**From:** [REDACTED]  
**Sent:** 05 February 2026 21:40  
**To:** Planning  
**Subject:** Application No. 3/2026/0013  
**Attachments:** 52884.jpg; 52886.jpg; 52882.jpg

Planning Application 3/2026/0013

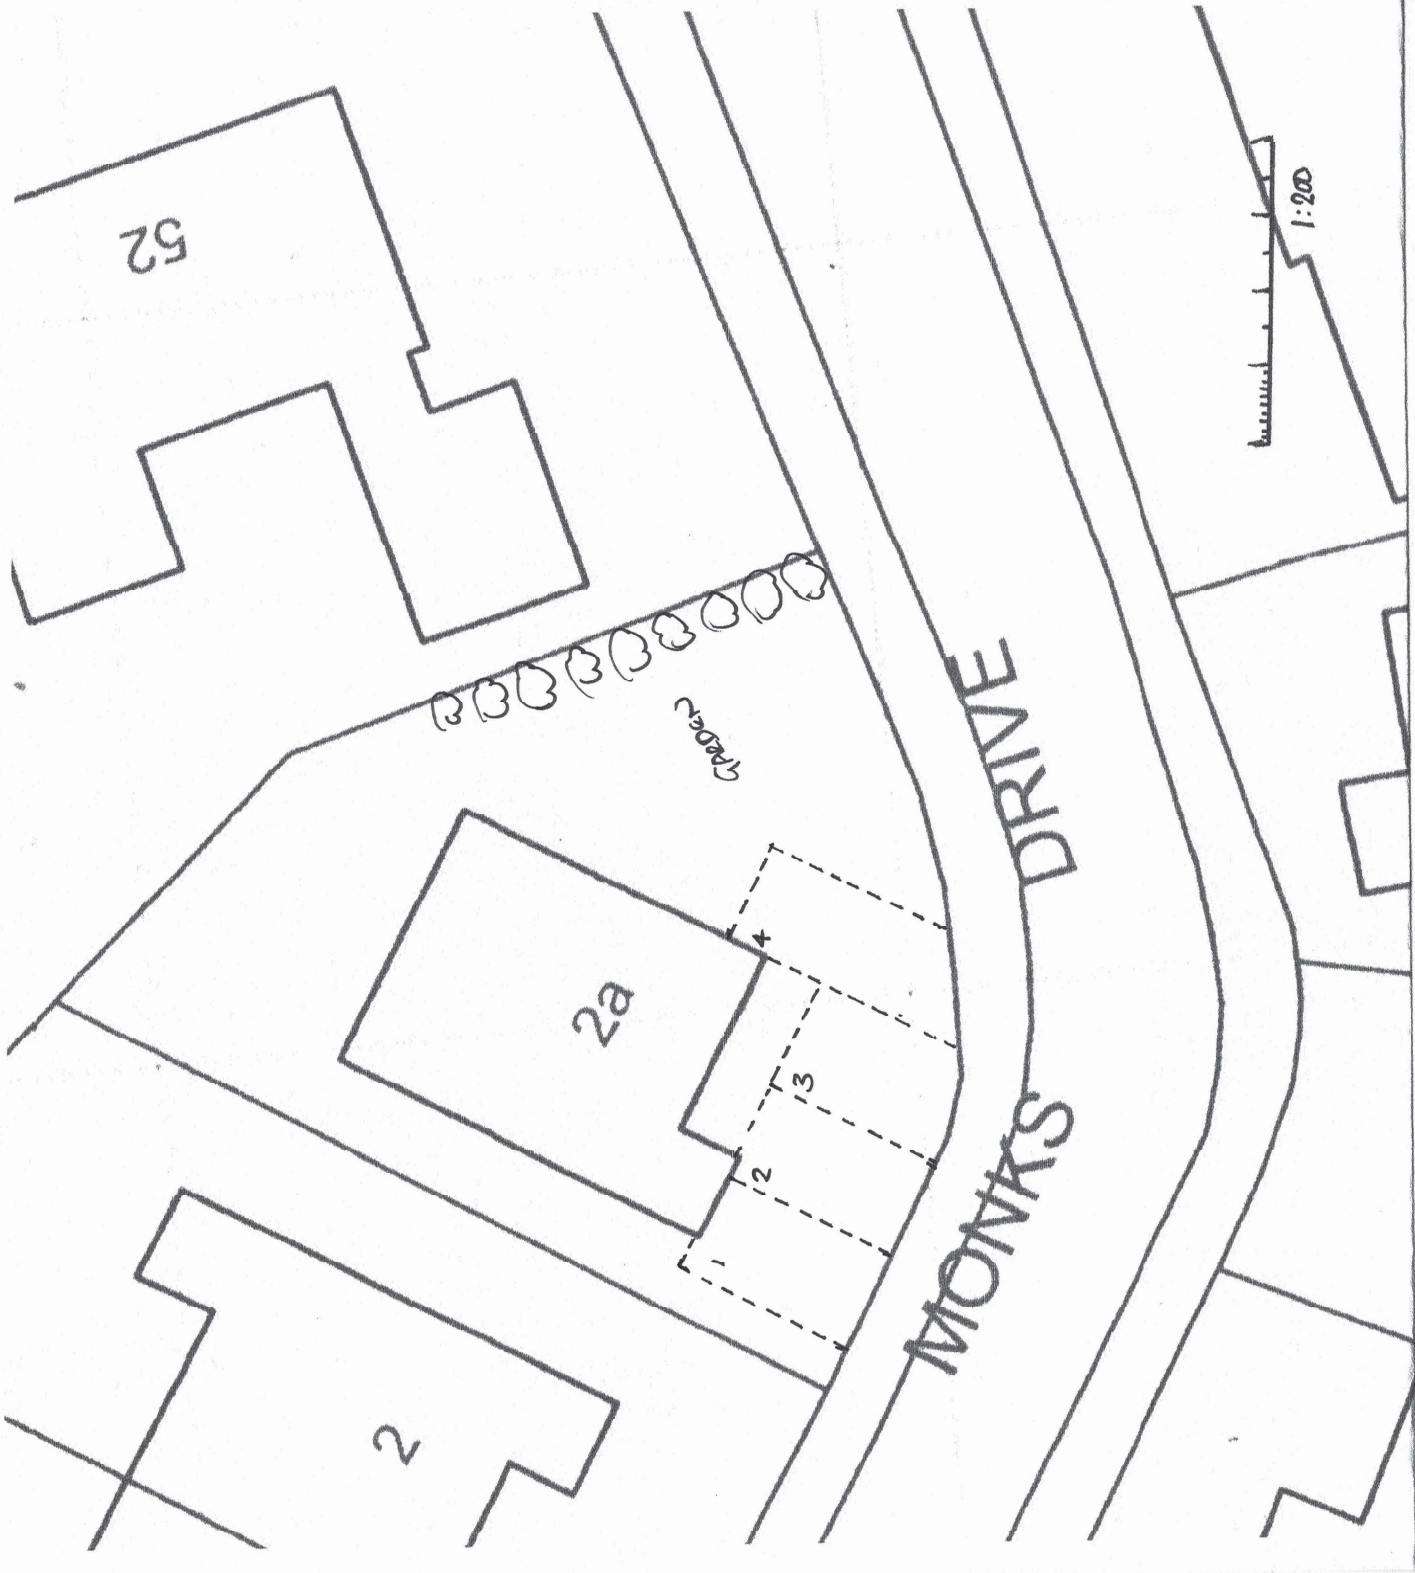
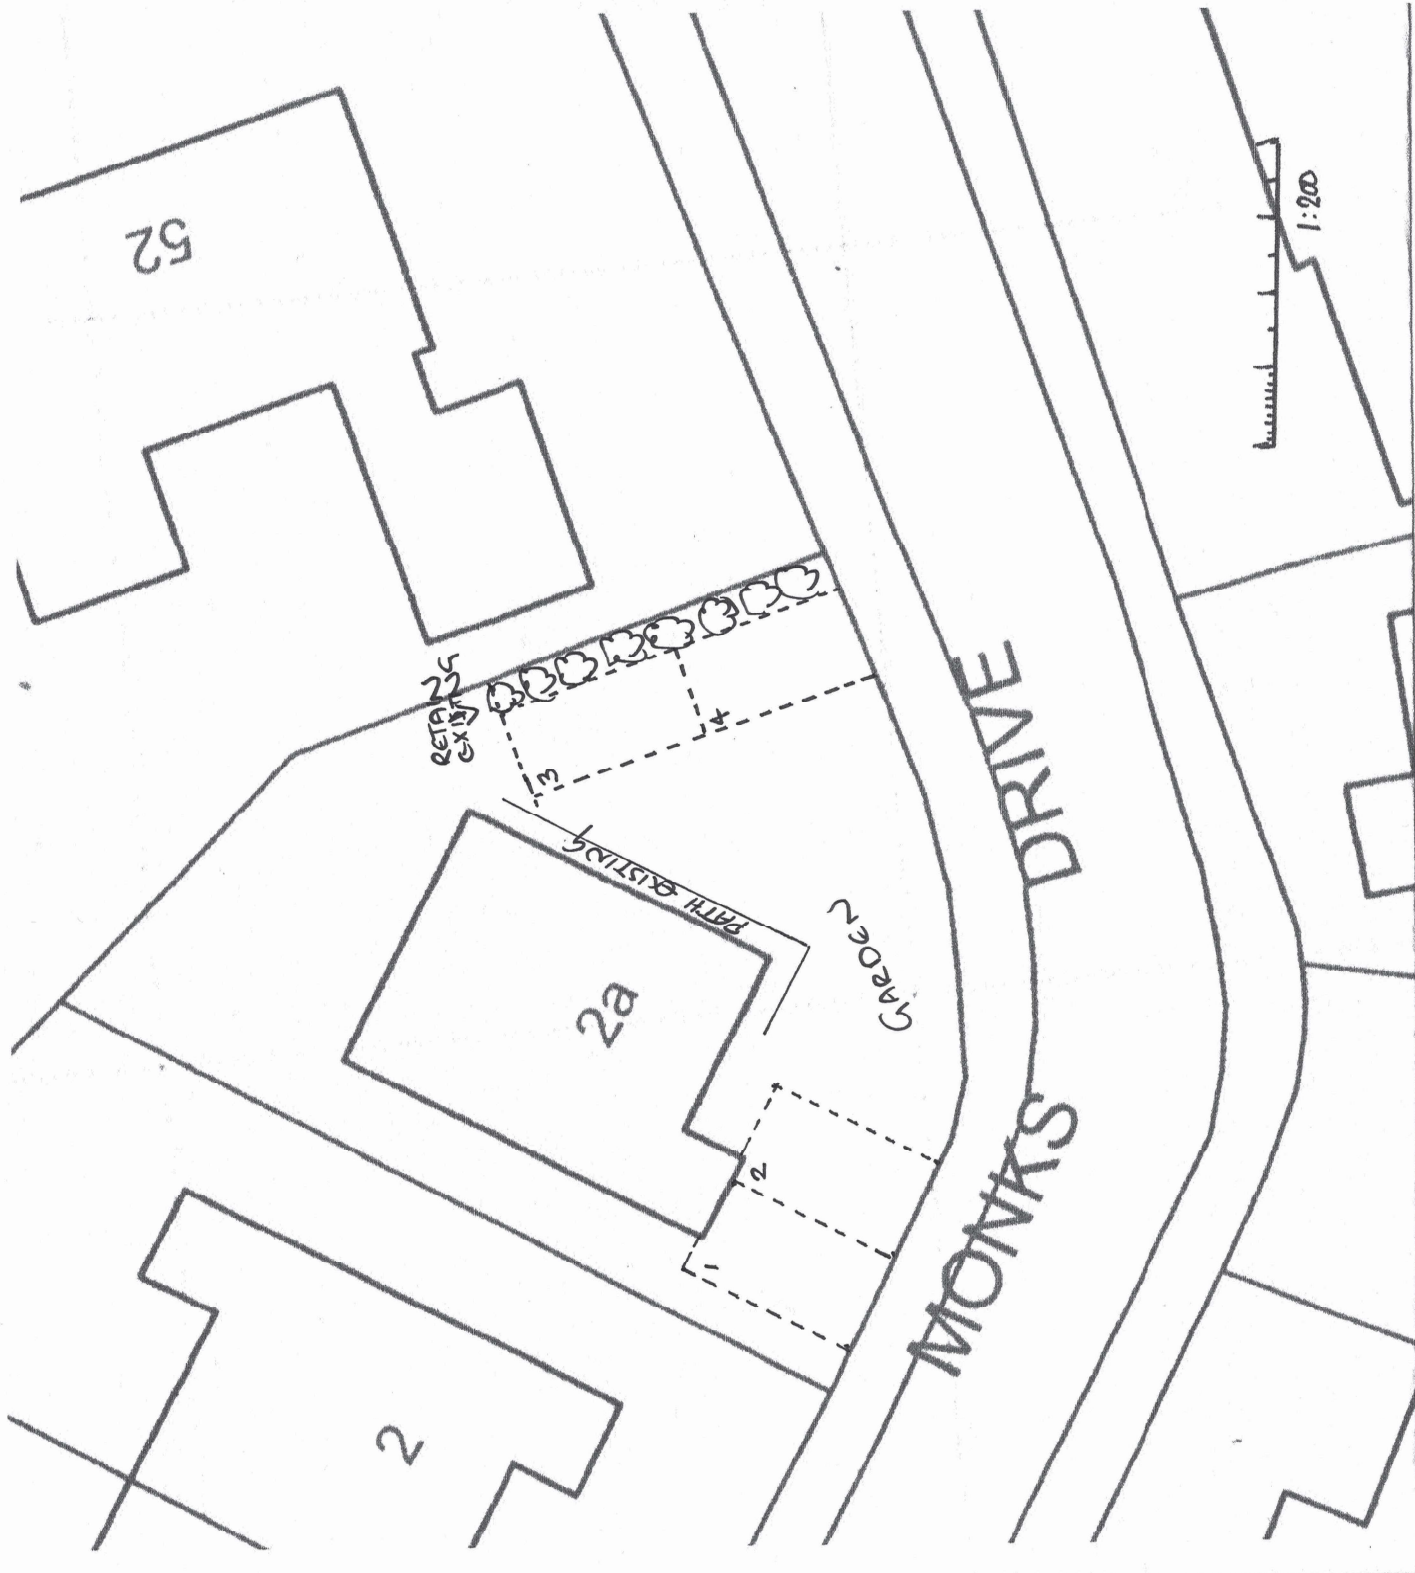
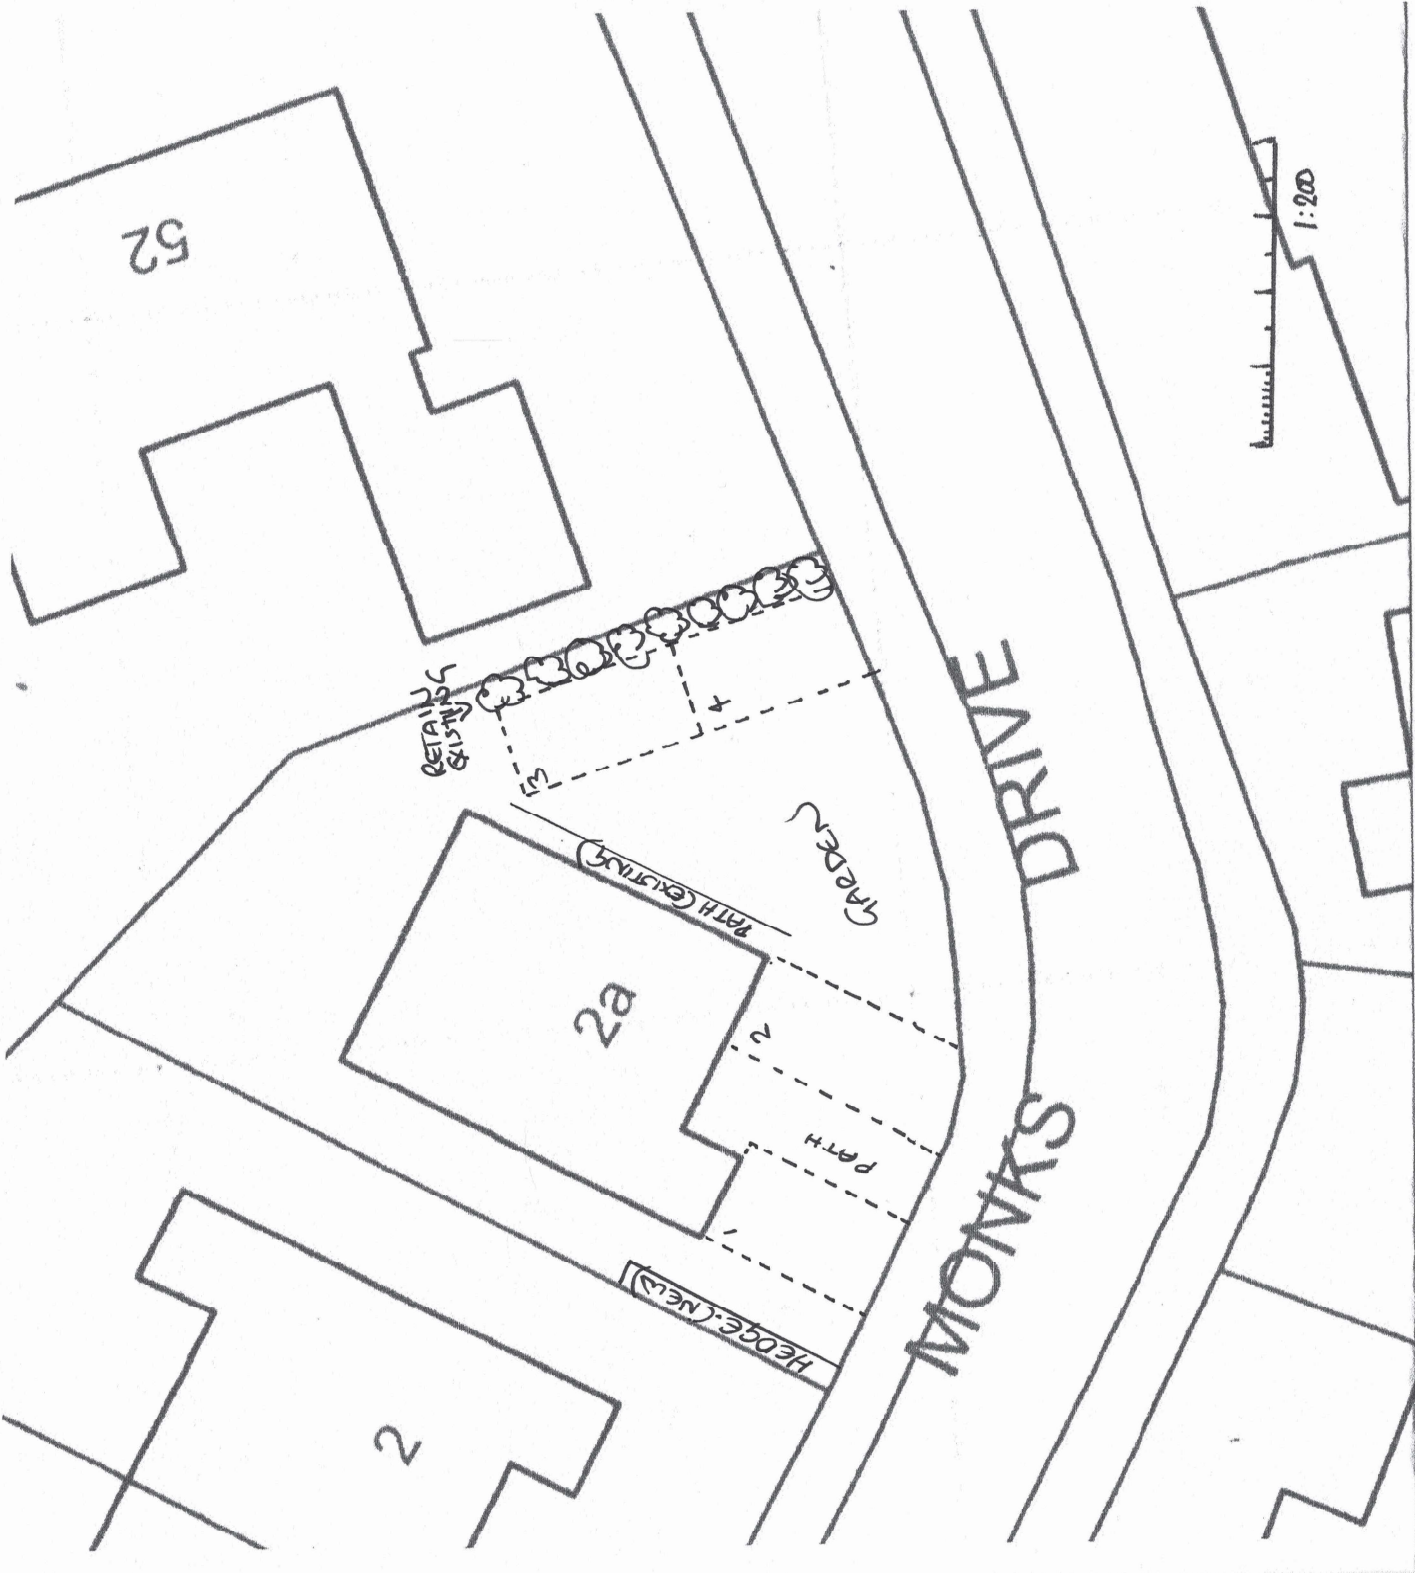
Any parking spaces utilised in front of the garage door, do not meet the 2.4m x 4.8m size and if used as a parking space they will cause an overhang on to the public footpath (documented in the 1st application which was rejected)

The plans do not advise where the new drop kerb is going to be for all the new parking spaces. As you are aware 2A is on the narrow bend on Monks Drive. There is a safety risk to pedestrians and road users, there will be restricted view on exiting the propose parking bays, especially if the staff reverse out of the carpark on to the road due to the vets customers parking on the footpath/road during the day, in the evening there is also 1 to 2 transit vans that park at the top of monks drive/footpath every night.
